**Engineering Review**

**FINAL DRAINAGE REPORT  
FOR  
HOMESTEAD NORTH AT STERLING RANCH FILING NO. 1  
EL PASO COUNTY, COLORADO**

**March, 2022  
Project No. 25188.00**

**SF2213**

EXISTING DRAINAGE MAP HOMESTEAD NORTH

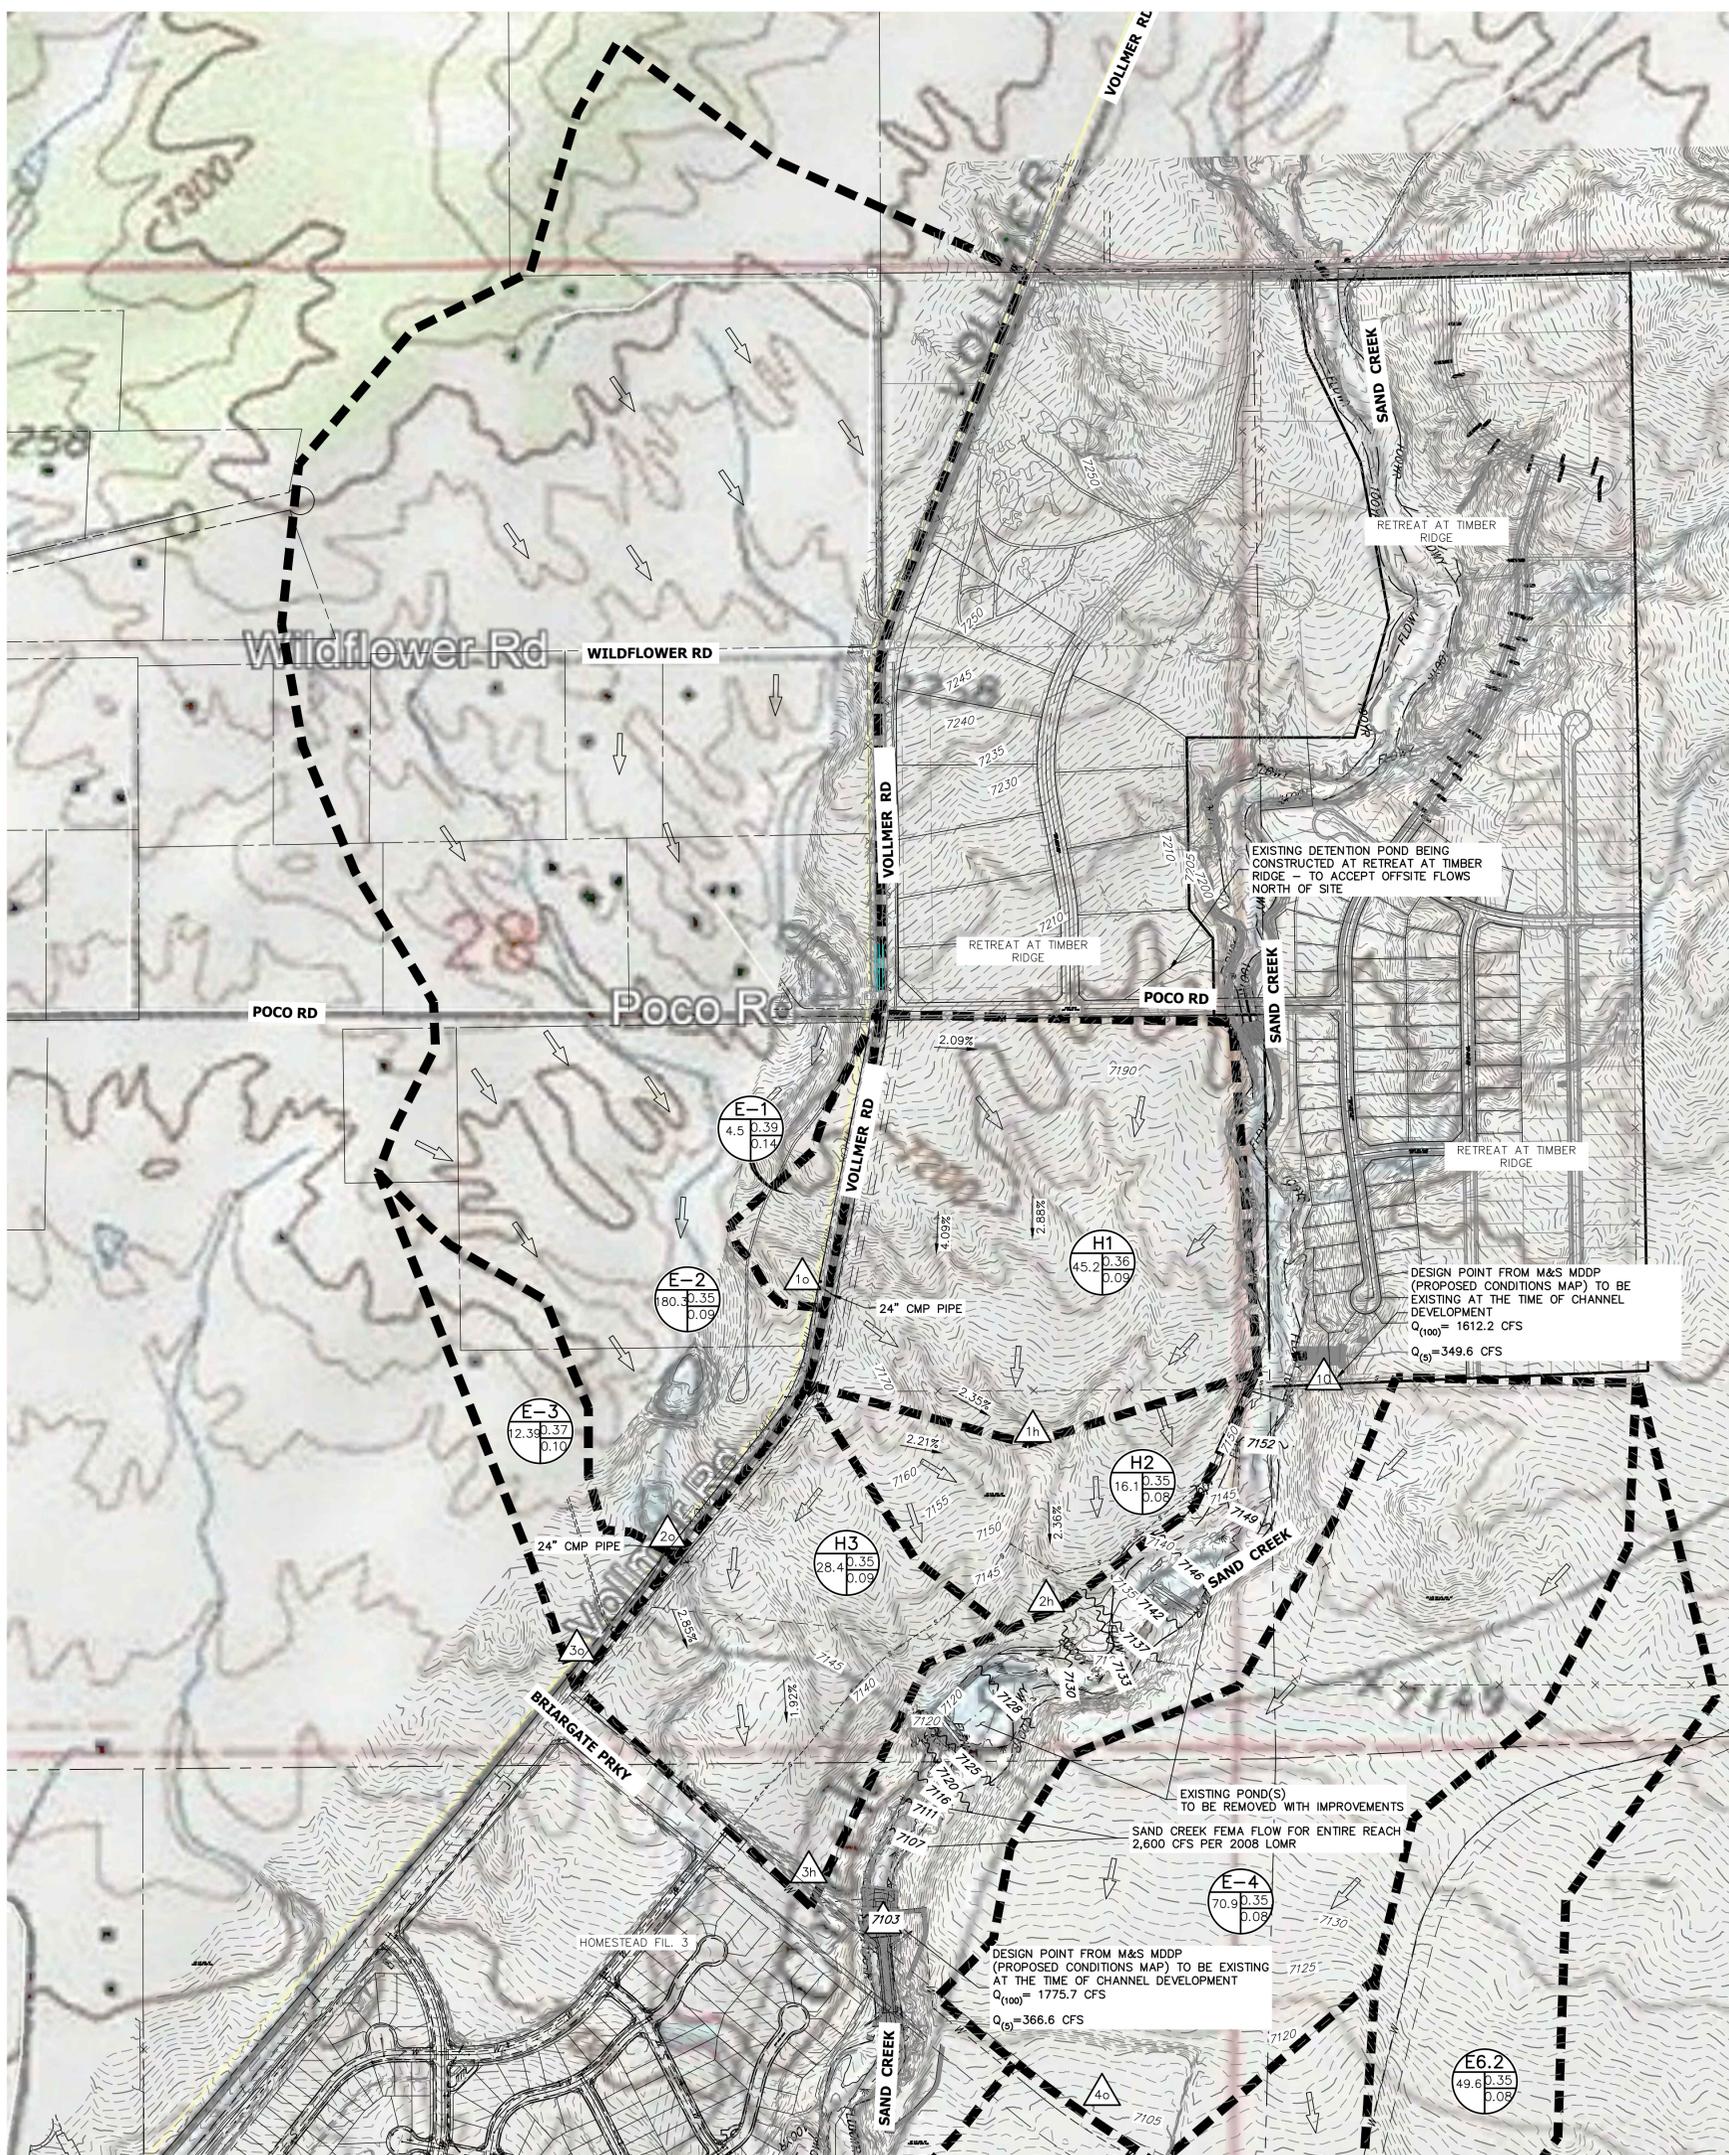
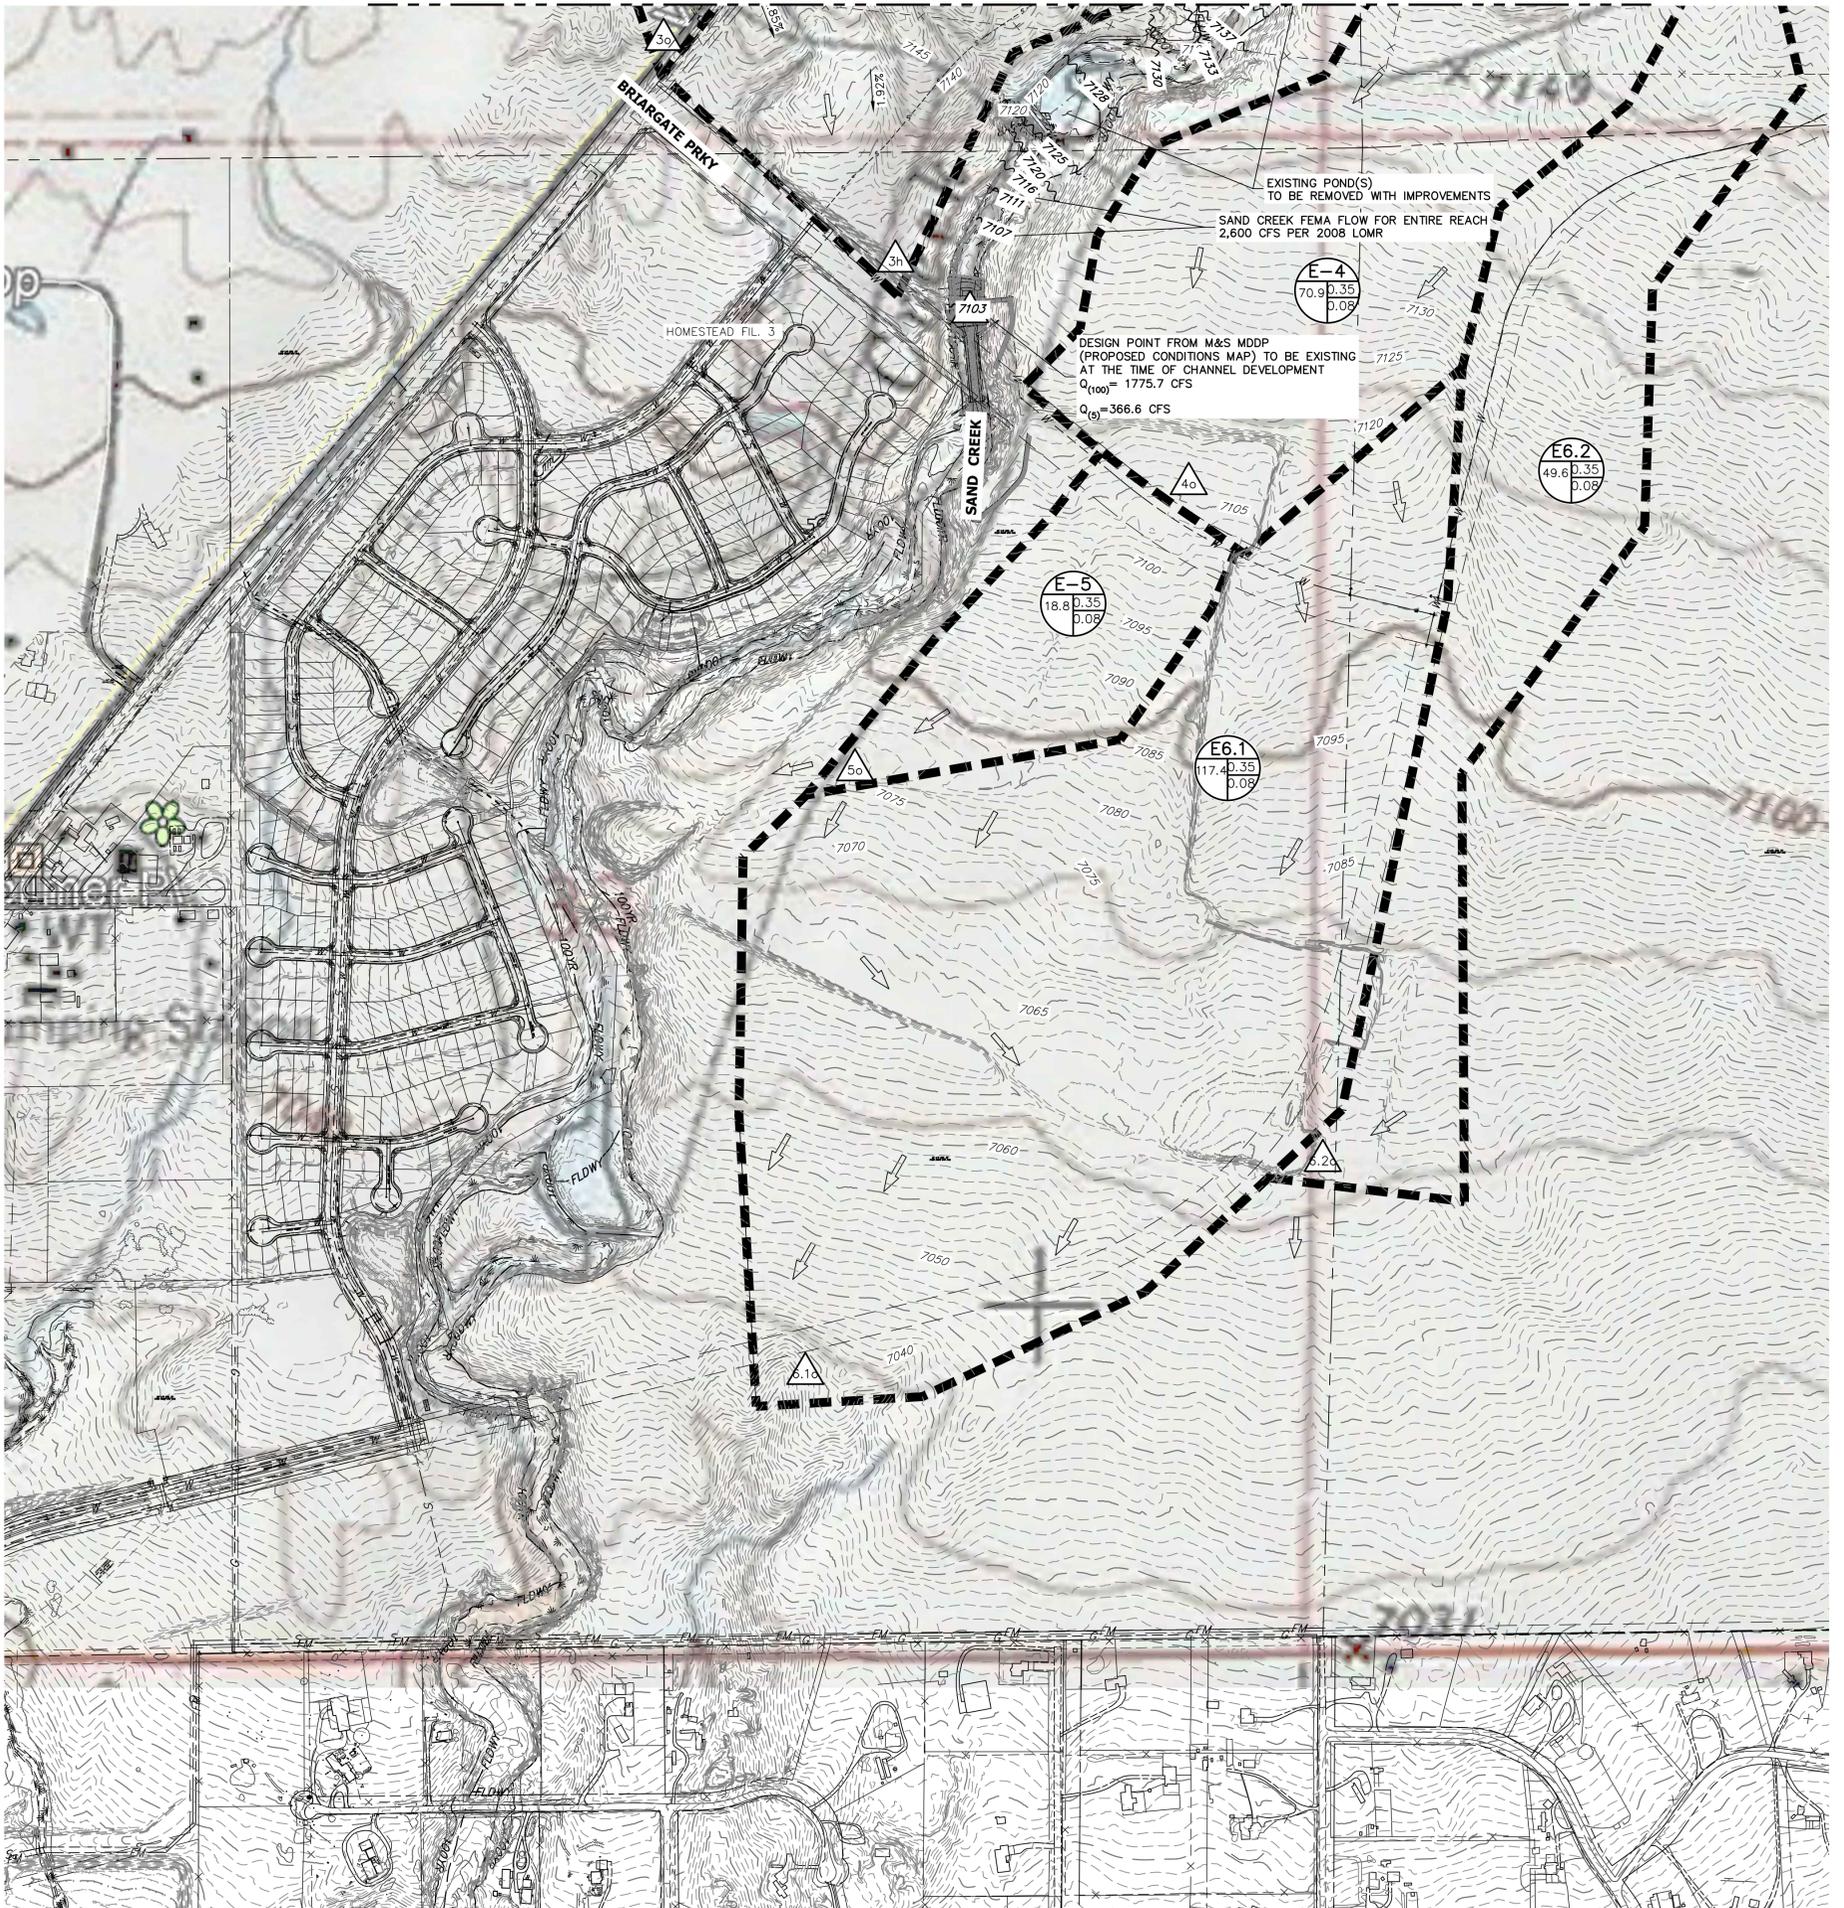
← Show on plan

↑  
highlighted values  
don't match  
drainage plan
